Application No: EP/22/21/HH
Site Address: 15 The Plantation East Preston BN16 1LD
Description of works: Erection of rear extension and loft conversion with rear dormers and side gables

This proposal is for the erection of a rear extension and a loft conversion with rear dormers and side gables. This council agreed to object to this proposal on the following grounds.

Plans & Elevations As Proposed

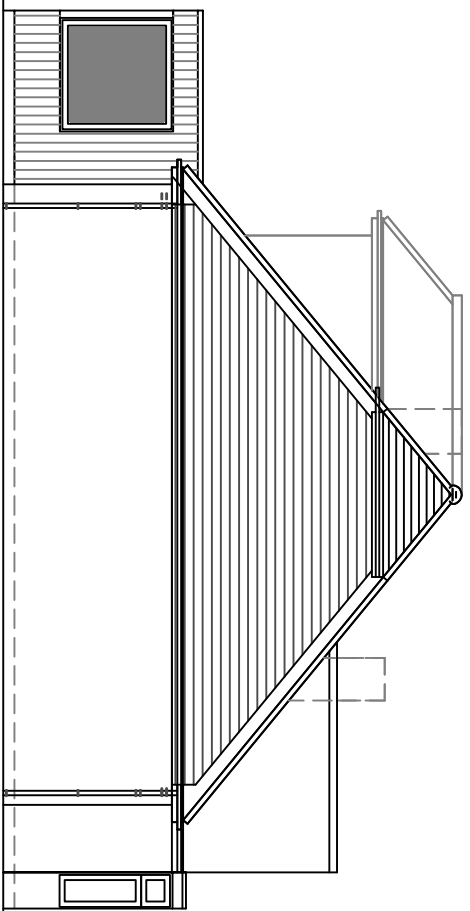
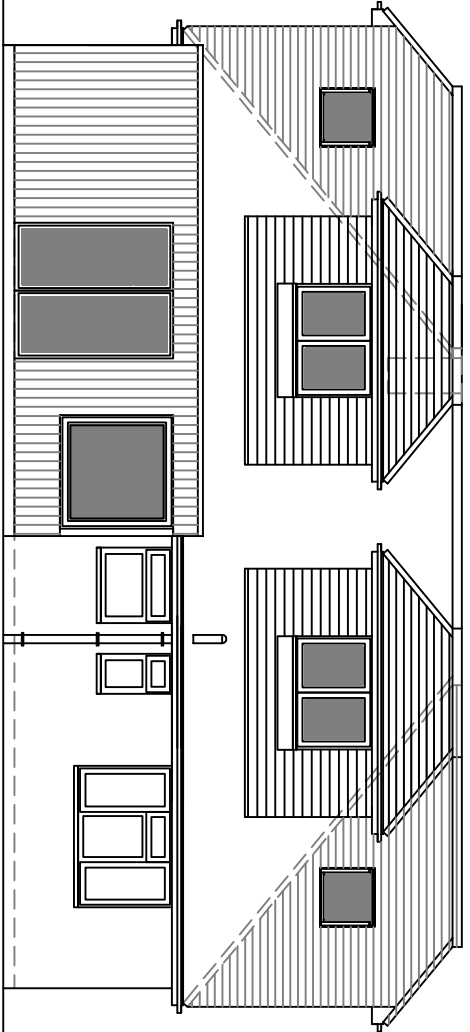
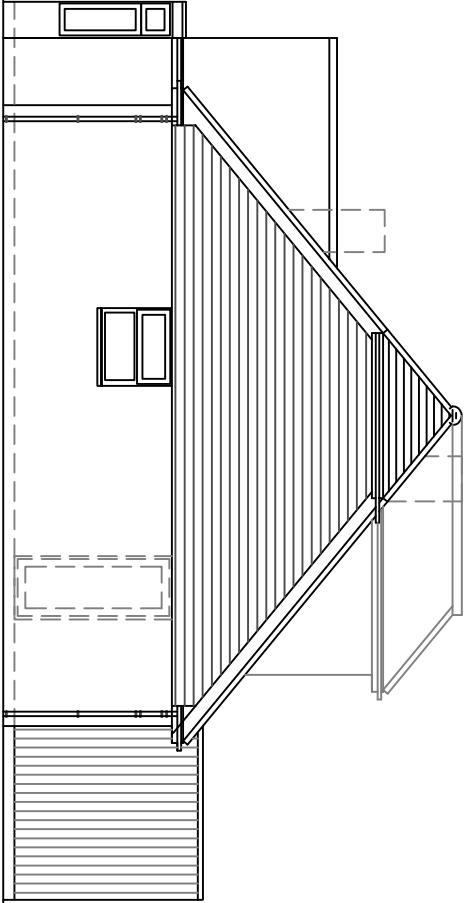
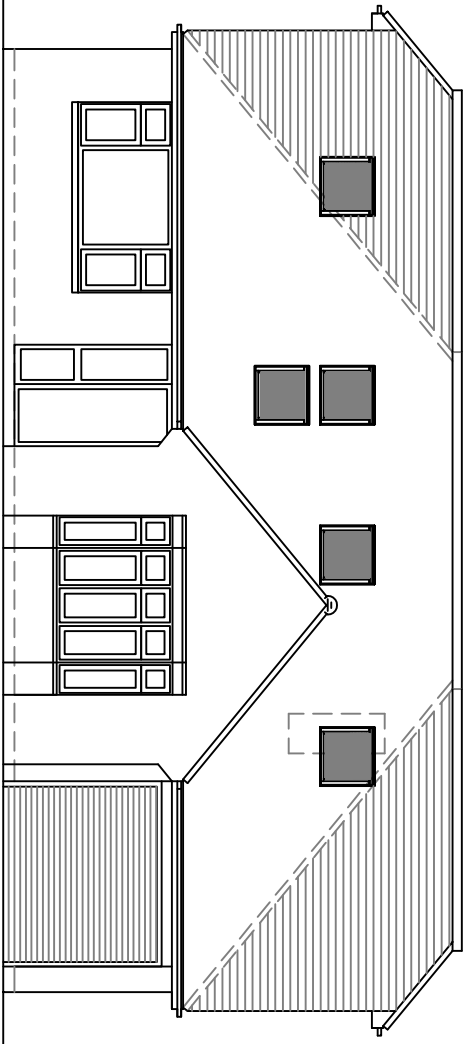
The proposal does not reflect the characteristics of the site and local area. (Arun Local Plan, Policy D SP1). The proposal will transform the look of this property from a compact house into something out-of-keeping with every other property in the road, not responding to and complement the existing character and appearance of the building and the wider townscape in terms of scale, massing, materials, openings and roof form (Arun Design Guide, Part M). No others have side gables nor, we believe, (such a number of) rooflights at the front. Alteration of the basic form of the roof will also be contrary to Policy 3 of the East Preston Neighbourhood Plan.

The proposal is bulky and heavyweight and will not sit comfortably with the existing properties in The Plantation. This council does not believe the scale of development keep with the general confines of the overall character of locality . (Arun Local Plan, Policy D DM1) Similarly, this council does not believe this proposal meets the comments in Part M of the Arun Design Guide, The scale, massing and positioning of extensions should be visually subservient to the existing property in order to ensure that the latter remains the dominant form . The same section of the Design Guide goes on to say, Positioning extensions below the roof ridge line of the existing property will also help to create visual subservience ; the side extensions in this proposal are in line with the roof ridge line and therefore contrary to the Arun Design Guide.

The proposed rear dormers could result in a loss of privacy to adjacent properties in The Plantation as well as properties in Vermont Way. (Arun Local Plan, Policy D DM1)
